Ask for: Erika Davies
Telephone: 01832 742207
Planning Services: Planning.ENC@northnorthants.gov.uk
Our Ref: NE/21/00804/FUL
Your Ref:
Date: 20 May 2021

Proposal : Single storey rear extension; retention and replacement of a number of UPVC windows including an exterior door at Orchard Cottage Main Street Fotheringhay Peterborough Northamptonshire PE8 5HZ .

Drawing Title
EXISTING AND PROPOSED PLANS, ELEVATIONS, SITE & OS

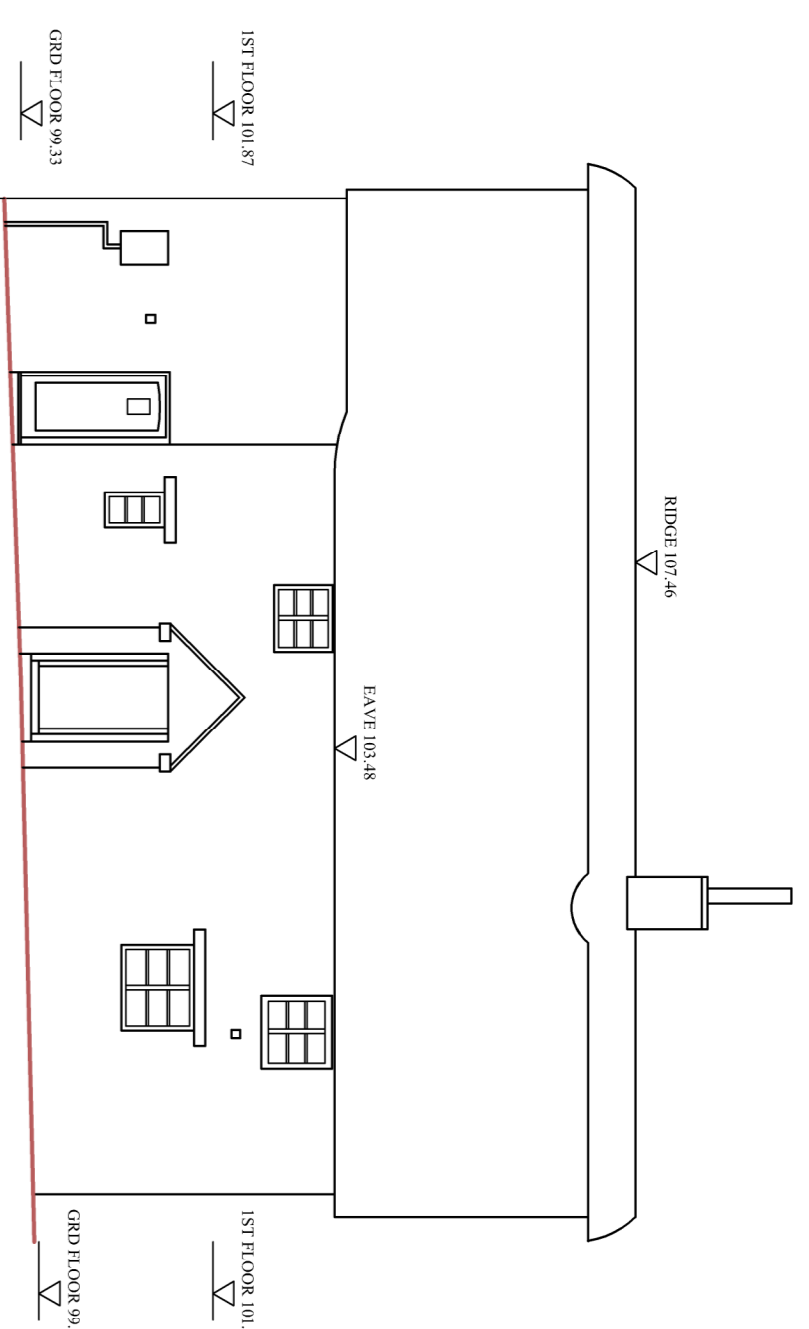
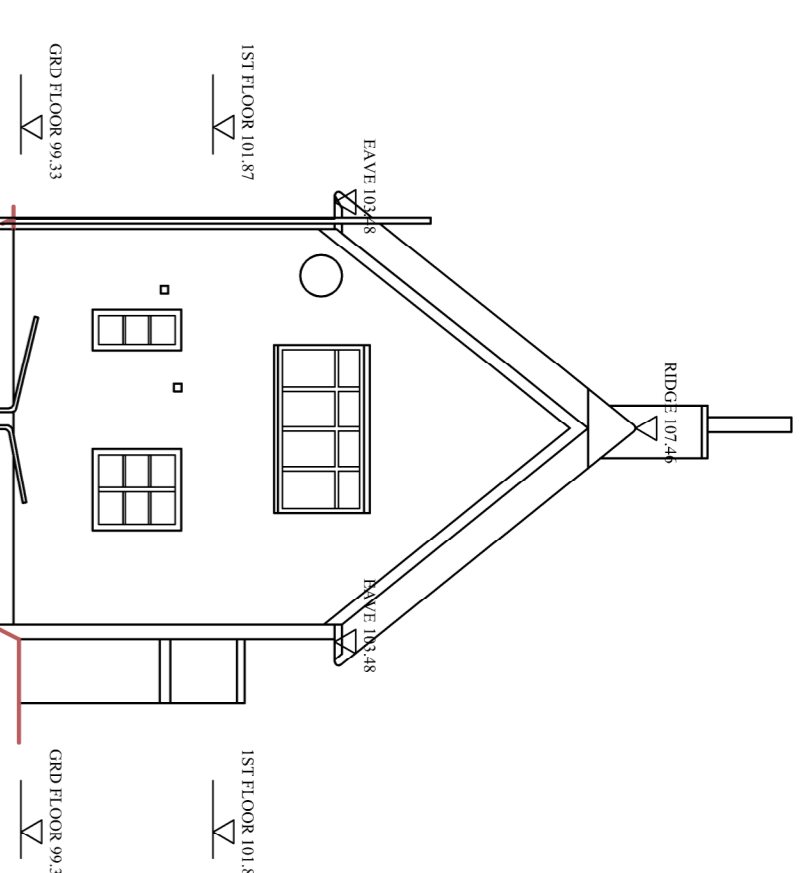
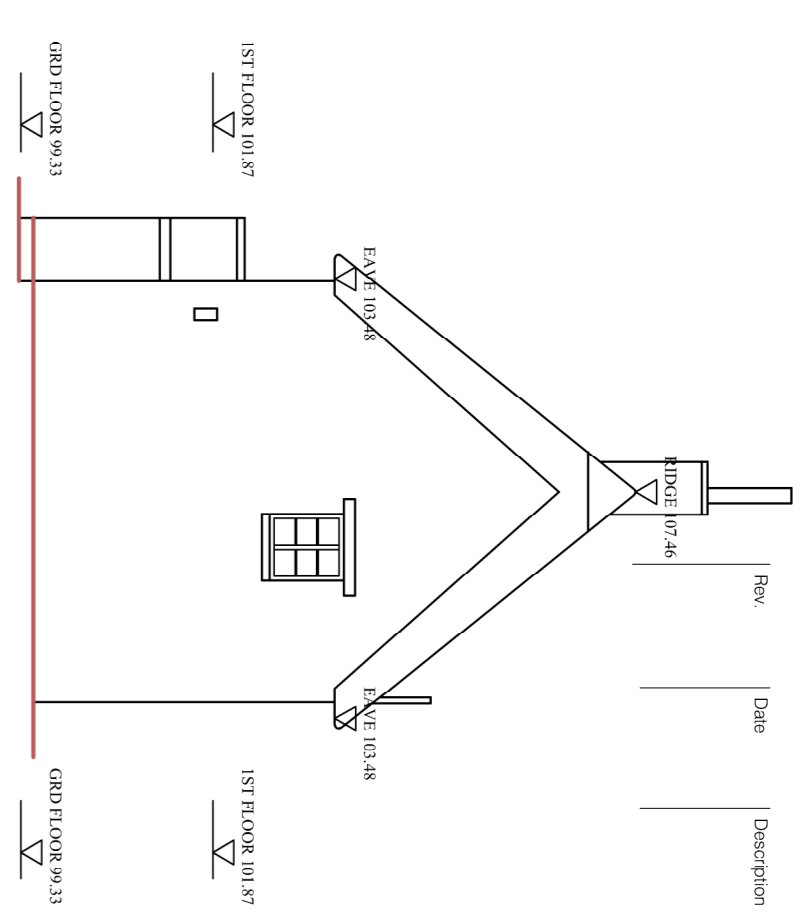
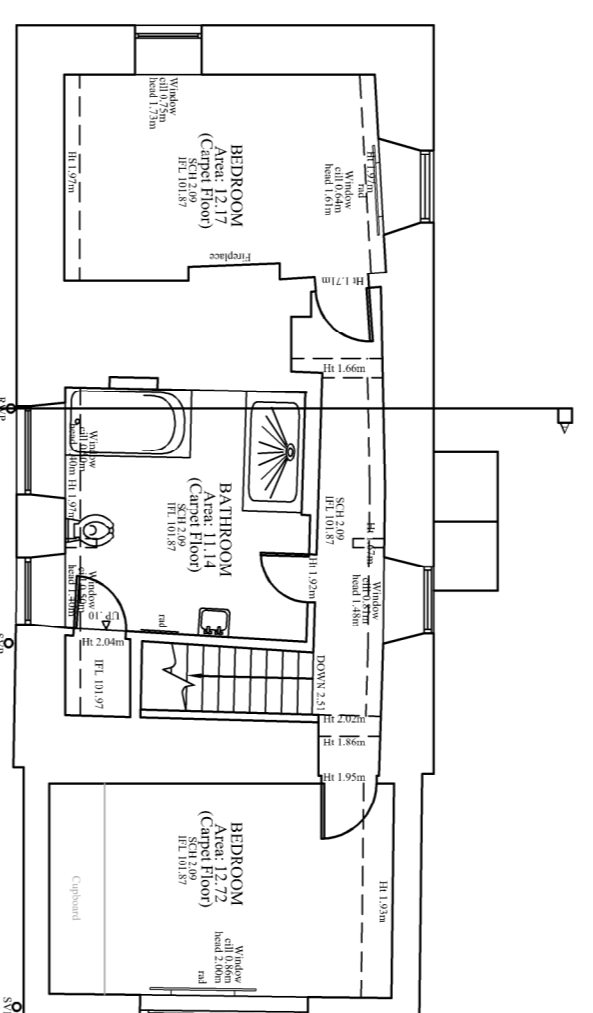
1. Please confirm in writing that you are happy with the amended description as given above. This amendment is suggested as descriptions for applications need to be clear, concise and precise.
2. The description of the elevations from the proposed drawings do not appear to match those on the existing drawings, please provide amended drawings showing the correct descriptions for the elevations.
